DEVELOPMENT FACILITATION TEAM
SUPPLEMENTAL SUBMITTAL

PROJECT NO. 2023-009688
Application No. SI-2024-00597

Attn. : DFT Chair
Cc. : Reviewers
Re. : **SI-2024-00597 – SITE PLAN DFT**
 : **2026 Central SW**
Project No. : **PR-2023-009688**

Sheet Title:  
**Landscape Plan**  
Sheet Number:  
**LS-01**

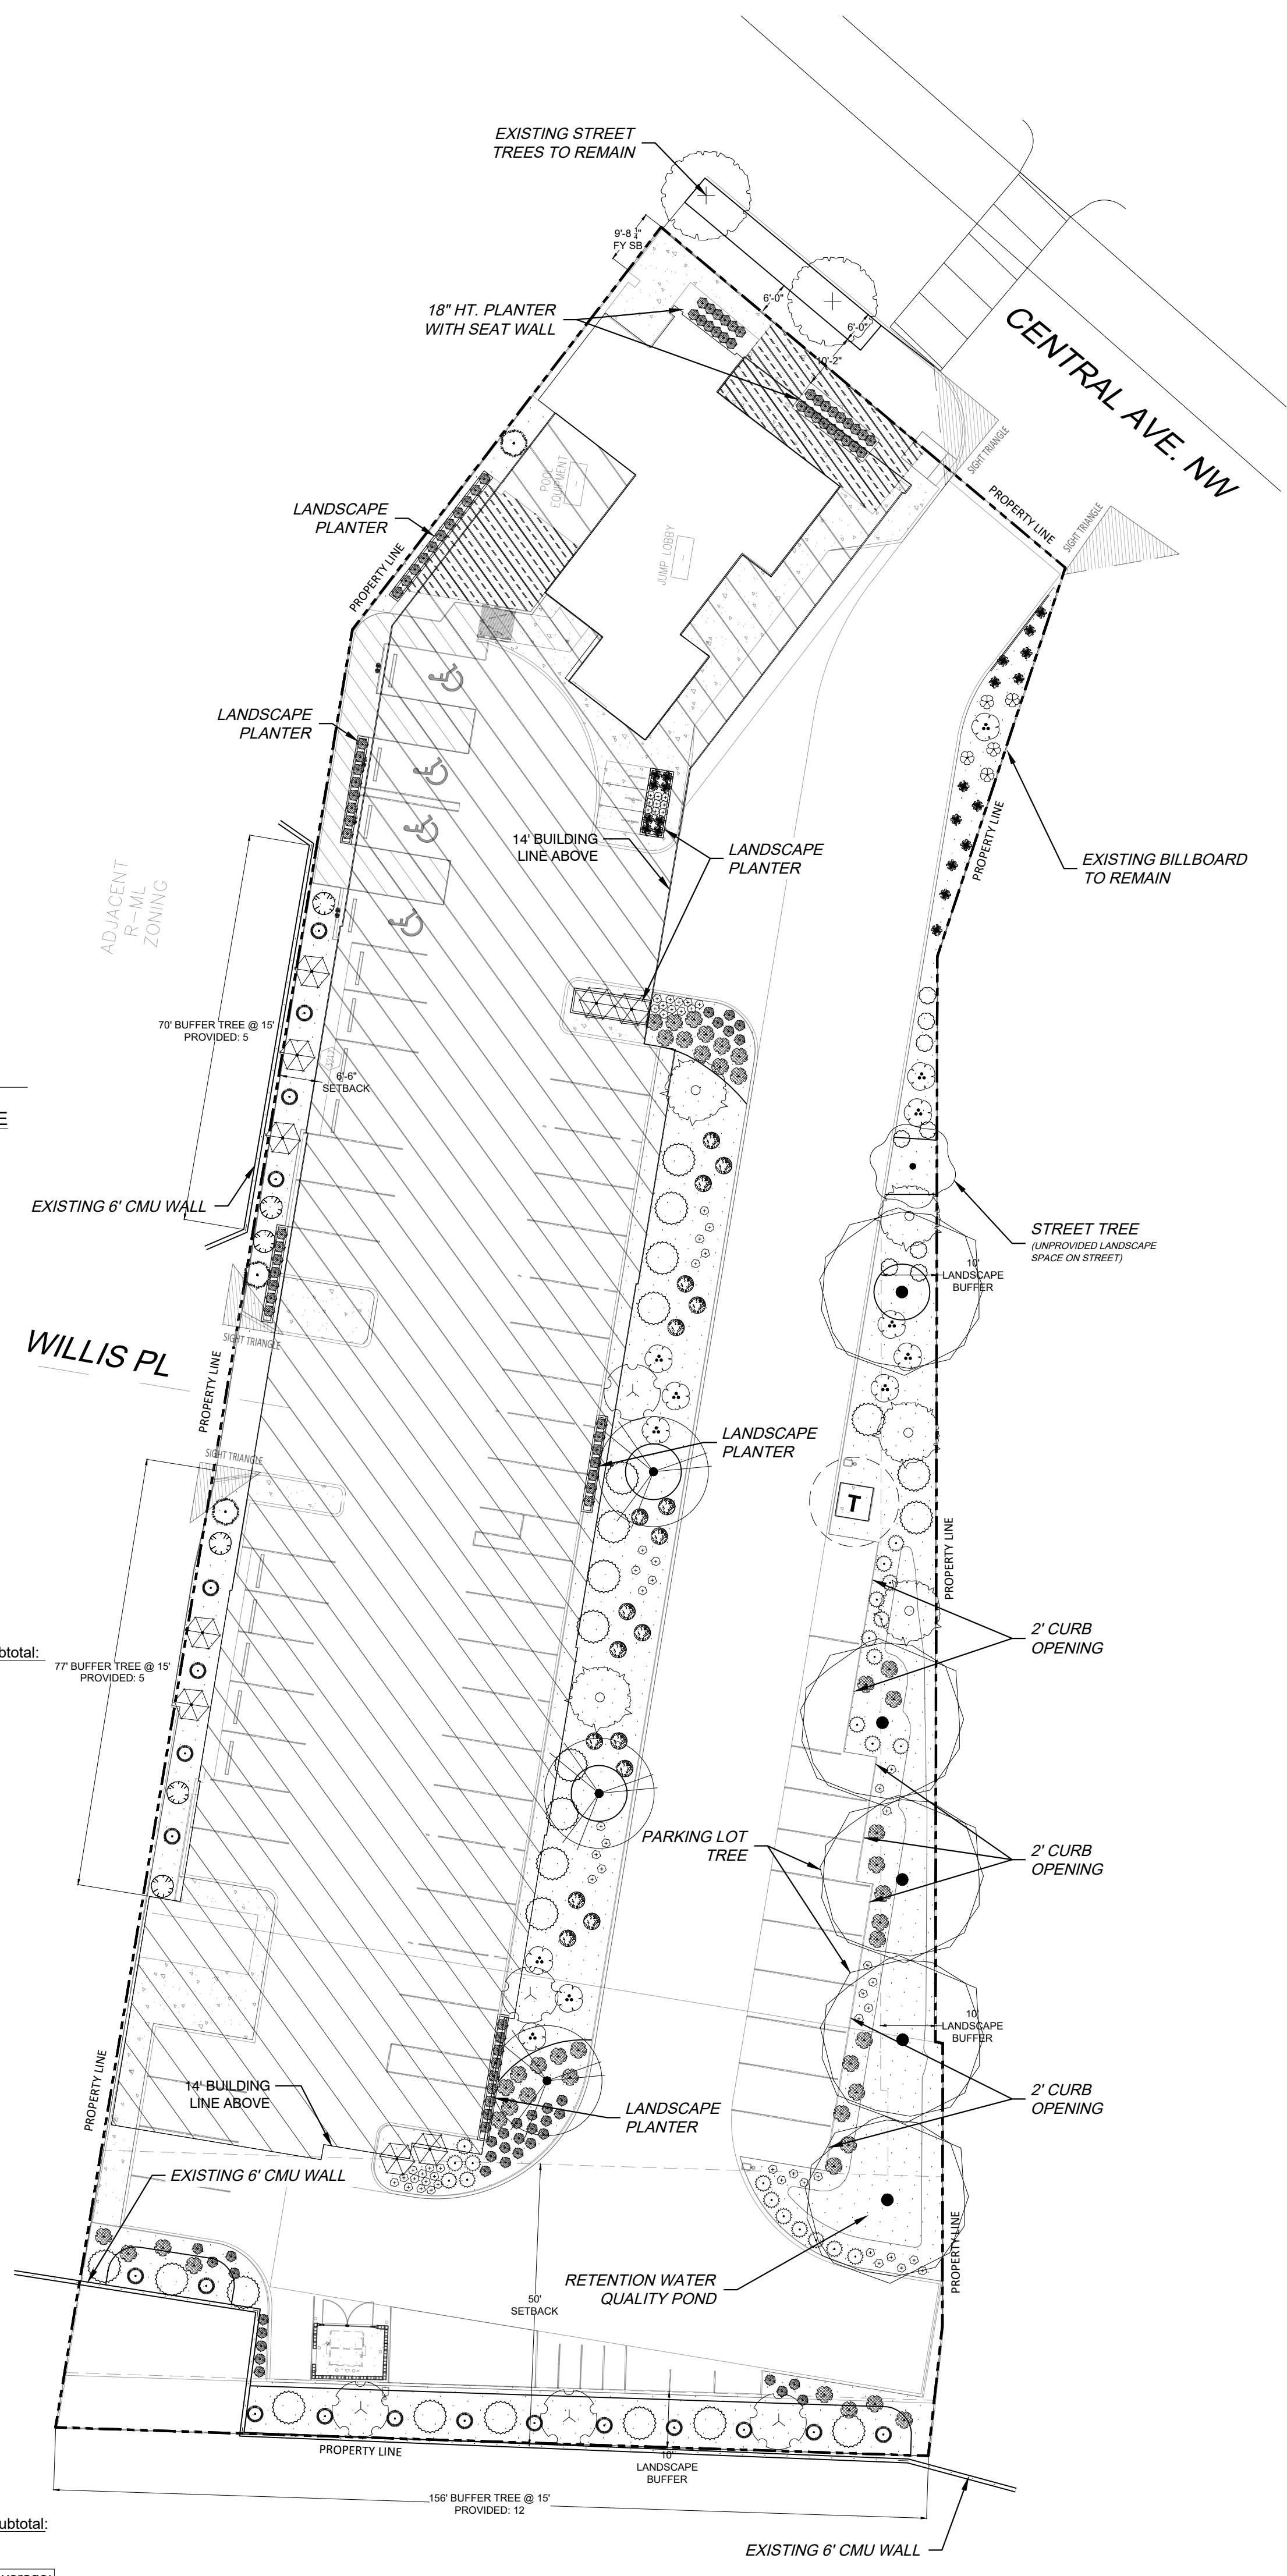
2 **Comment** - Propose larger canopy deciduous trees in larger landscaping areas to provide more shade on the hardscape. Oklahoma Redbud is generally not recommended per City Forester.

4 **Comment** - Per 5-6(C)(4)(i), shade trees planted approximately 25 feet on-center are required along all required pedestrian walkways. If the walkway is less than 25 feet long, at least one tree is required, or, where there is insufficient space for a tree, a trellis of at least 8 feet high for at least 5 feet along the walkway shall be provided. Confirm compliance.

- 8 **Comment** - IDO 5-3(D)(2)(b) Reference DPM 7.2.29 for Sidewalk/landscape buffer widths. Parcel is outside of a Center. This location on Central is within a Premium Transit Station Area, a Major Transit Corridor, and a Main Street Corridor. Therefore, Central requires an 8–10-foot sidewalk and a 6–8-foot landscape buffer. Provide widths of existing features on the landscape plan to match the site plan and show street trees in the landscape buffer.

- 11 **Comment** - The clear sight triangle shall be maintained at all exits of parking areas and street intersections. Please show the site triangle on the landscape plan and demonstrate compliance with this code.

Response: See attached landscape drawings.

Response: See attached landscape drawings that show the existing 2 trees in the front walkway area.

Response: See attached landscape drawings.

Response: See attached landscape drawings.

2 TREE DETAIL

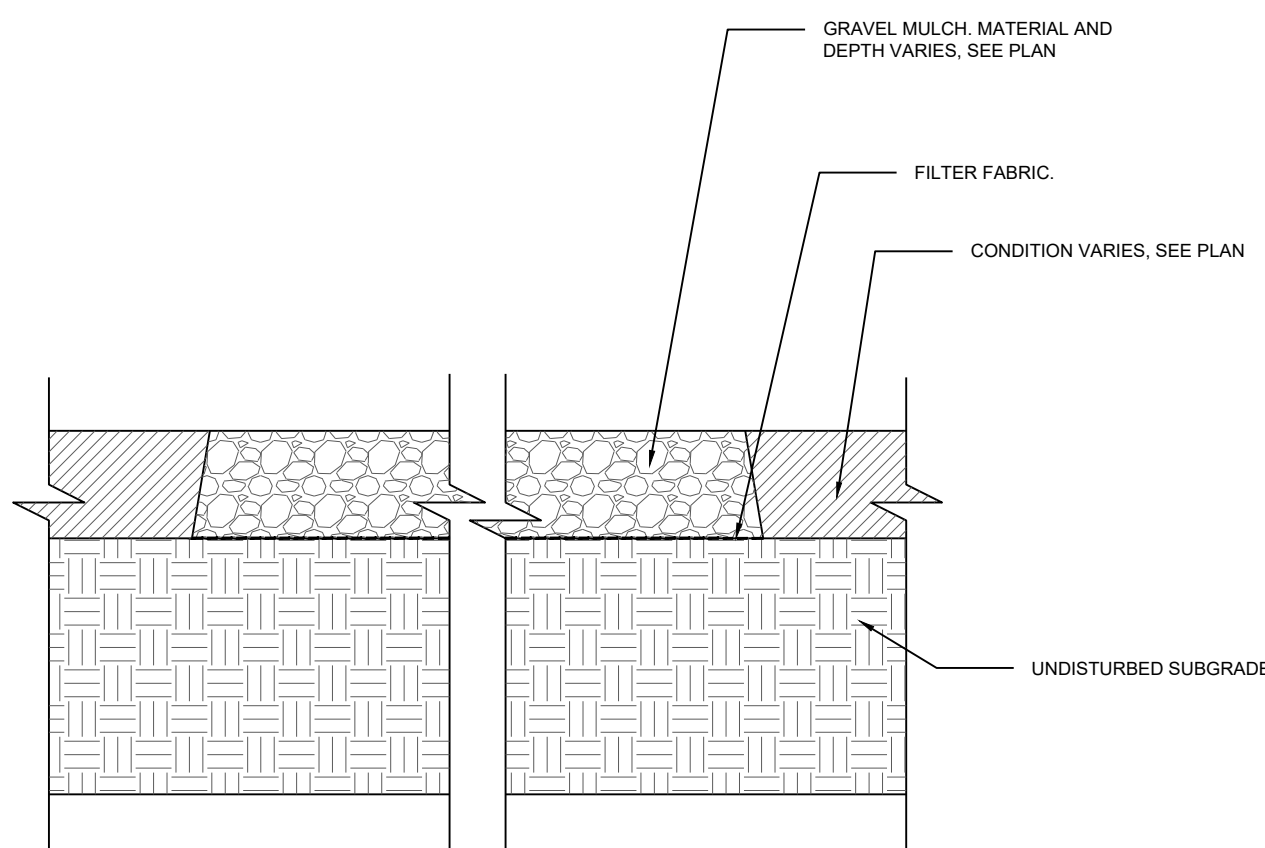
7 **Comment** - Per 5-6(C)(5)(e), organic mulch is required as ground cover under trees within a 5- foot radius around the tree trunk, but not directly against the trunk. In these areas, weed barrier fabric is prohibited. (See figure below.) Modify your tree planting detail to reflect this requirement. The organic mulch used under the trees can be counted towards non gravel mulch used on the site as discussed

earlier under 5-6(C)(5)(c). Please make sure you are mention 'Organic Mulch' on your planting details.

Response: See attached landscape drawings.

Sheet Title:  
**Materials Plan**

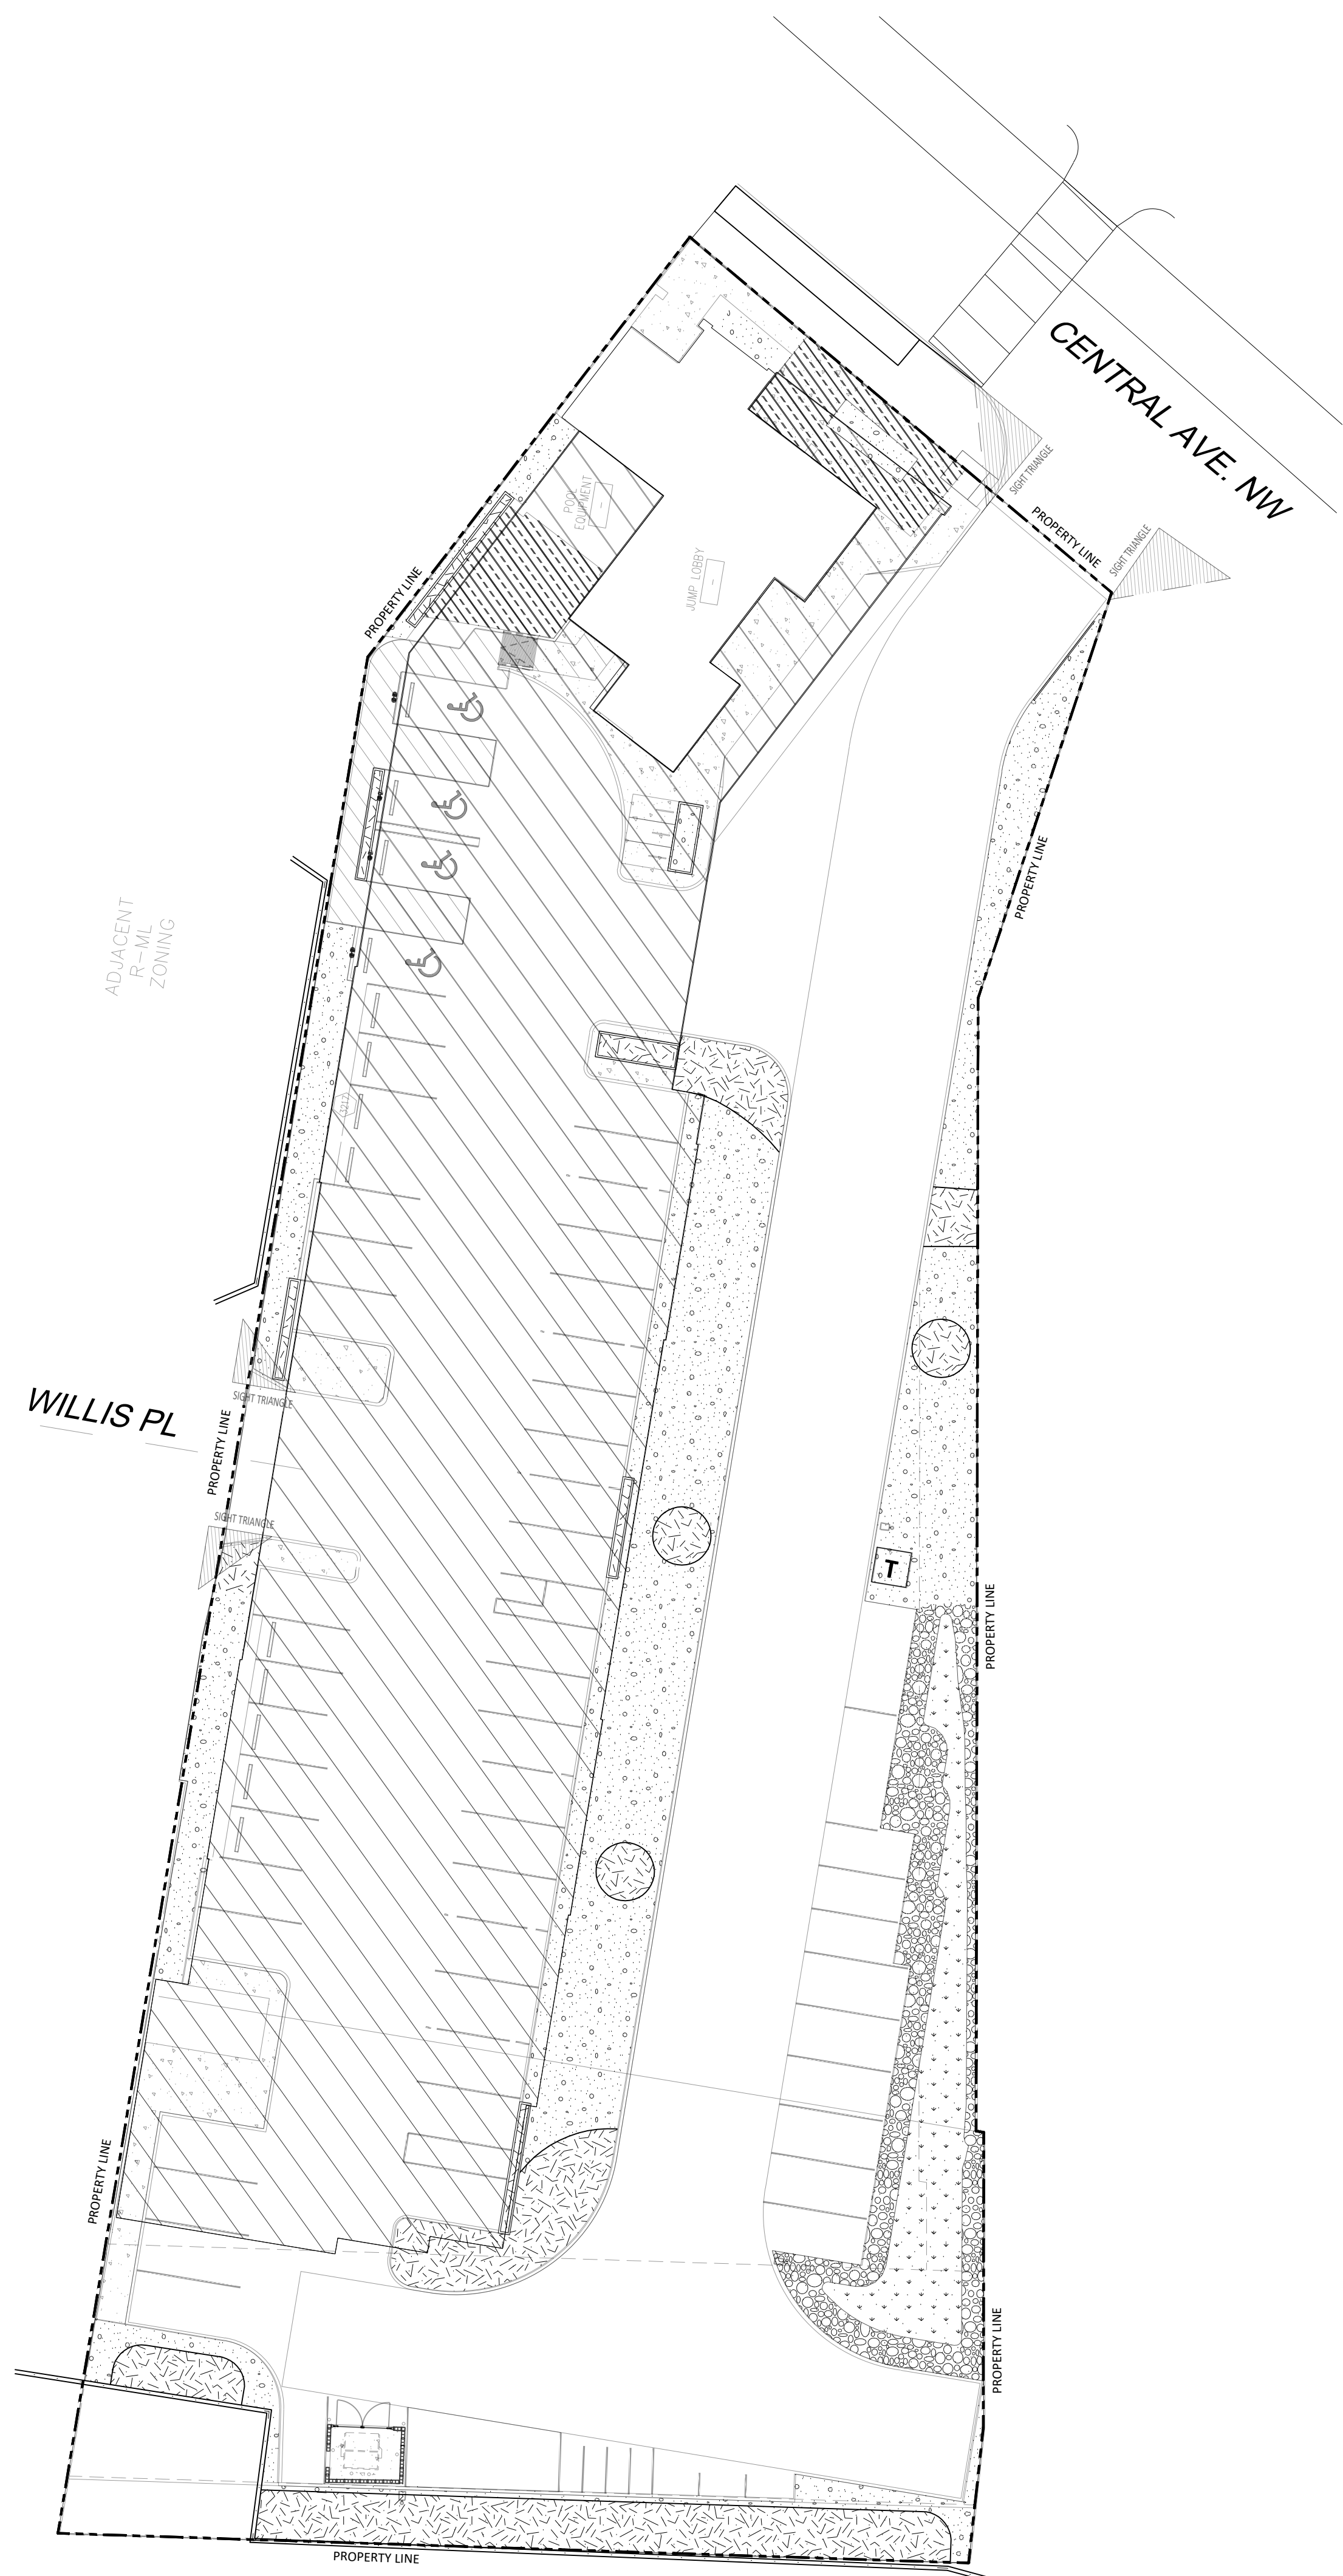
6 **Comment** - 5-6(C)(5)(c) The use of gravel or crusher fines as ground cover is limited to a maximum of 75 percent of any landscaped area, or 50 percent in DT-UC-MS areas. Confirm compliance. Calculate the organic mulch ring around trees as your non gravel groundcover. Provide a breakdown showing square footage for both.

Response: See attached landscape drawings.
